**Permit Number: BCOM2411-0001**

Description: **40 x 65 pad for fuel tank storage/(3) 4000 gal, (1) 550 gal/**

Site Address: **742 CLAUDE WHITE RD**

500SKDW

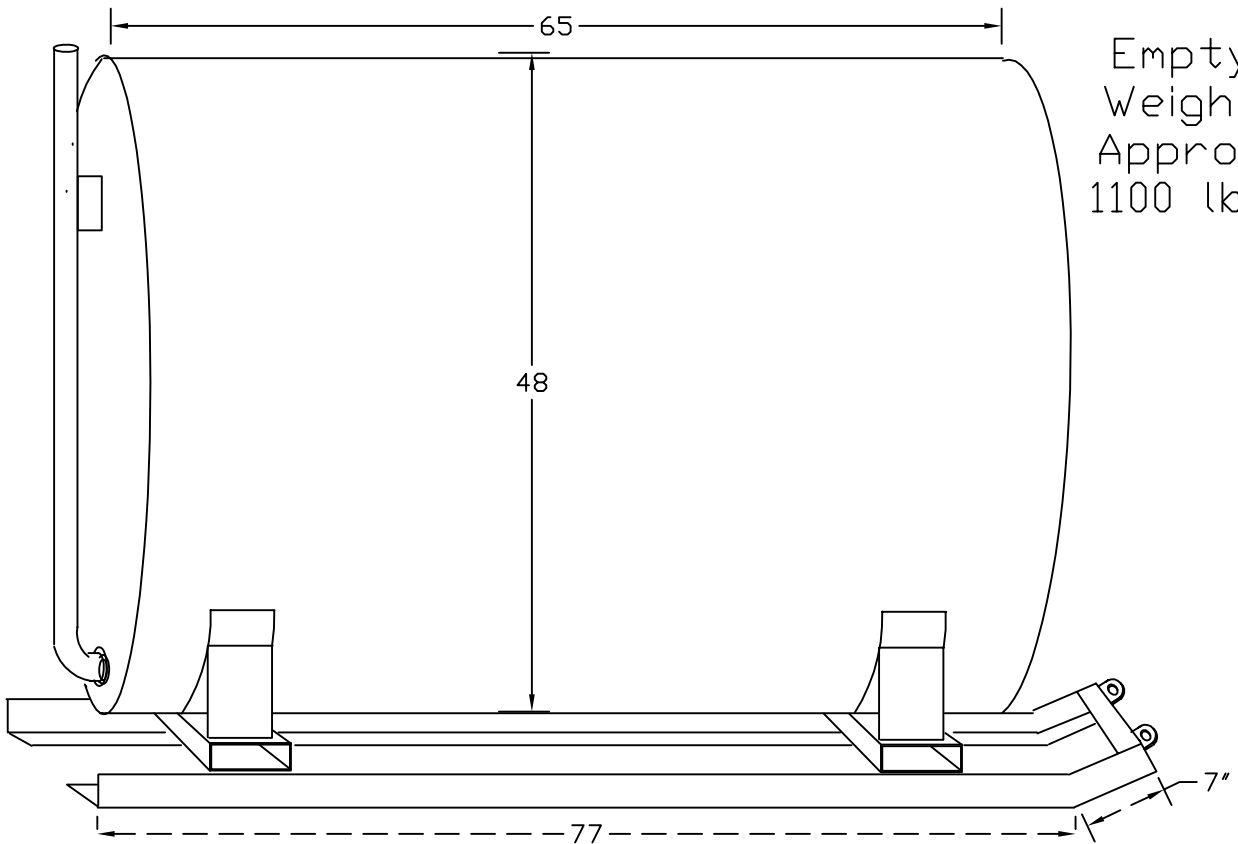
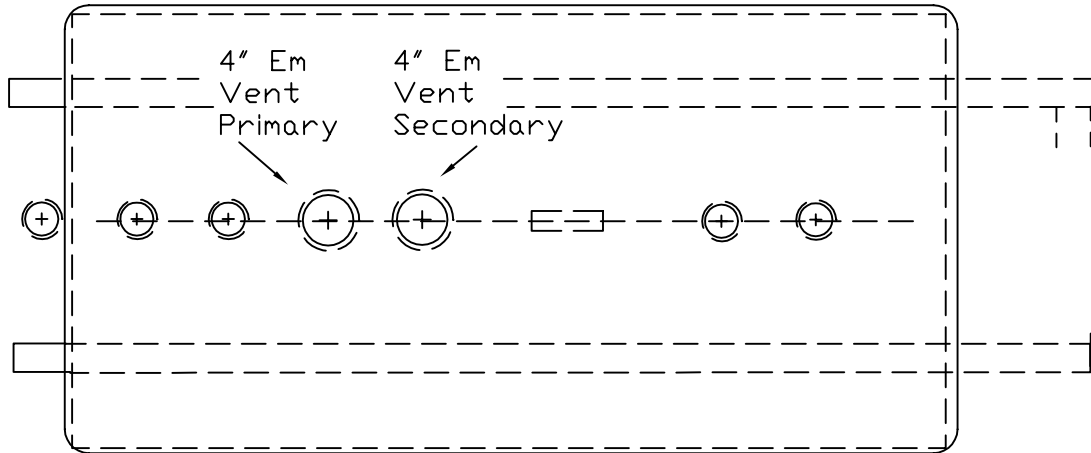
SENT DATE	RETURNED DATE	DUE DATE	TYPE	CONTACT	STATUS	REMARKS
Review Group: ALL						
11/18/2024	11/27/2024	12/4/2024	FIRE MARSHAL	Roger Sullivan	DISAPPROVED	see attached letter
Notes: See attached letter.						
Review Group: AUTO						
11/4/2024	11/4/2024		COMMERCIAL INTAKE	CP Bucket	APPROVED	
Notes:						
11/4/2024	11/5/2024	11/19/2024	COMMERCIAL BUILDING REVIEW	Brad Sutton	DISAPPROVED	
Notes: Need more information. Are the tanks going on a concrete pad? On the dirt? Do you have compaction information for the site if installed on grade? Do you have a design for the concrete support slab if on concrete?						
11/4/2024	11/13/2024	11/19/2024	FIRE MARSHAL	Fire Bucket	DISAPPROVED	see notes
Notes: Need specification & data sheets on tanks, fuel dispensers, emergency controls, secondary containment dimensions around tanks, tank emergency venting & overfill protection and impact protection around tanks.
